COUNTY COUNCIL'S RESPONSE TO CONSULTATION ON THE FOLLOWING DEVELOPMENT PROPOSAL

Application No: 20/02083/OUT-5

Proposal: Outline - Erection of 14 two-storey dwellings

Location: Land north of Hempton Road and west of Wimbourne Close, Deddington

Infiltration Basin Details:
 Design based on Impermeable Area of 0.676ha (as measured from architects layout with an additional 10% allowance for urban creep)

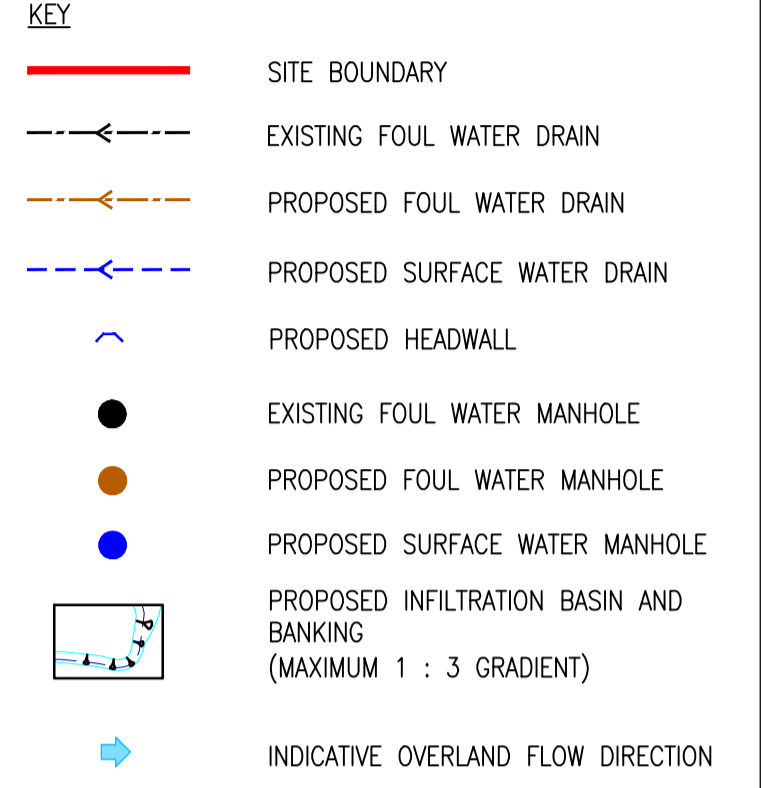
Whilst we have no concerns with the principles of the drainage proposal, i.e. infiltration, we do have concerns with the volumes of water being discharged managed adjacent to the highway and existing properties.

We will expect the detailed design to minimise this by implementing source control measures throughout the site and minimise the water discharging directly to the infiltration basin.
